Engineers Comments Regarding Surface Water Drainage

Application No: WA/21/21/DOC

Site Address: Wandleys Farm Wandleys Lane Walberton BN18 0QR

Description of Works: Approval of details reserved by condition imposed under ref APP/C3810/W/18/3209249 (WA/76/17/PL) relating to Condition Nos 3 - materials & finishes, 4 - surface water drainage, 5 - Written Scheme of Investigation, 7 - hard & soft landscaping and 8 - Construction Method Statement

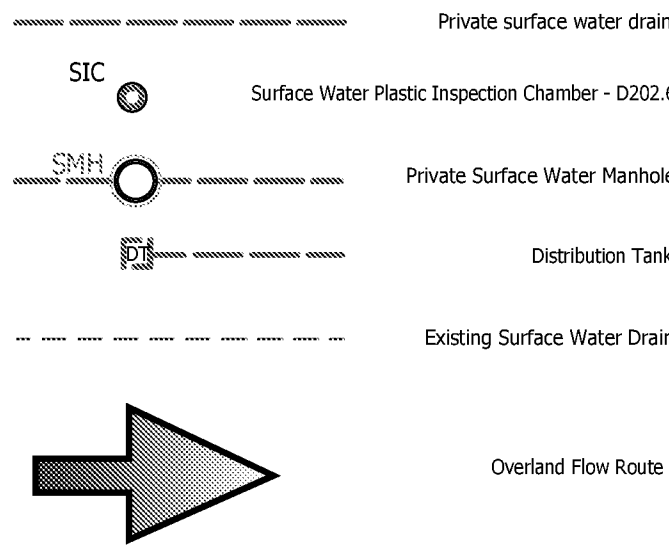
1. Please provide an impermeable area plan.
2. Please mark out the two different Hydrobrake model numbers on the drainage layout.
3. Please provide surveyed levels for the watercourse invert and top of bank. Please also model for a surcharged outfall. (Water at top of bank)
4. Please include a note to state what type of pipes are proposed (material). If the materials vary across the site, state as such.
5. Please include a note stating which cover types to use on inspection chambers/manholes on the drainage layout.
6. Please include sumps or silt traps upstream of all connections to permeable paving.

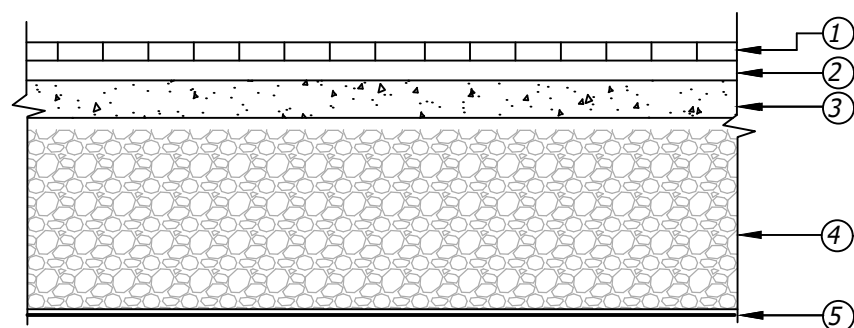
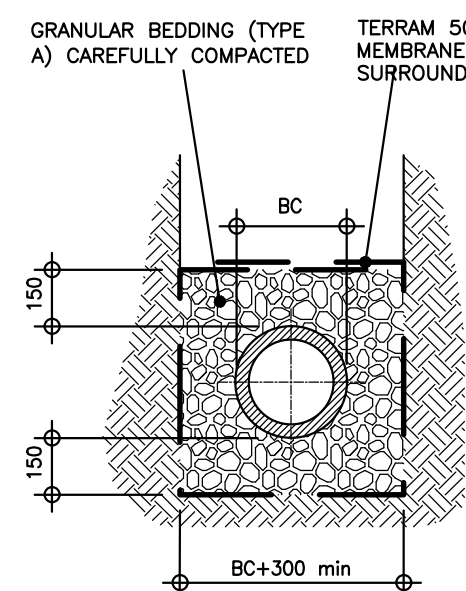
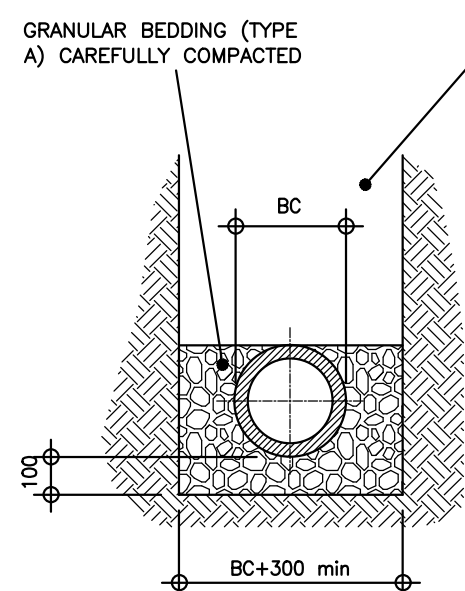
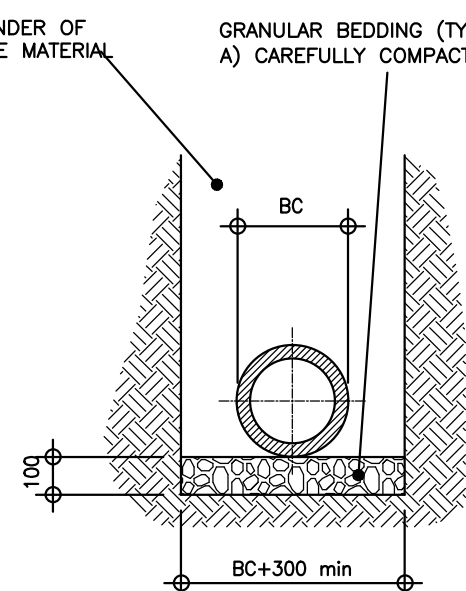
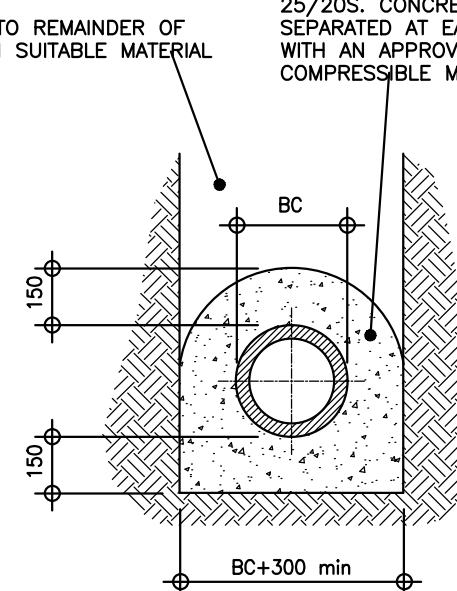
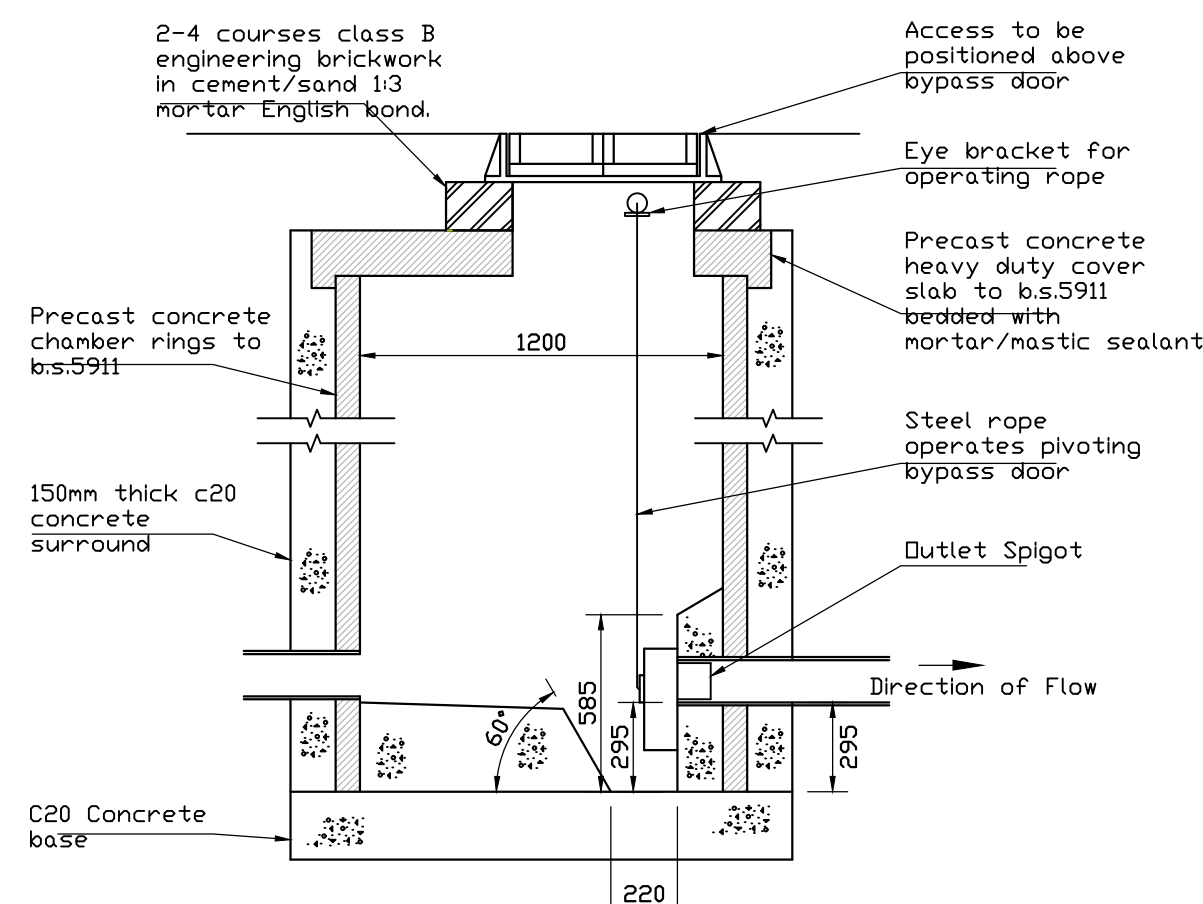
7. No construction detail drawings have been provided, please provide the following construction detail drawings:

- a) Pipe bed and surround
- b) Permeable paving including diffuser blocks.
- c) Manholes/inspection chambers/silt traps
- d) Both different hydrobrakes, in accordance with the calculations.
- e) Headwall to the watercourse
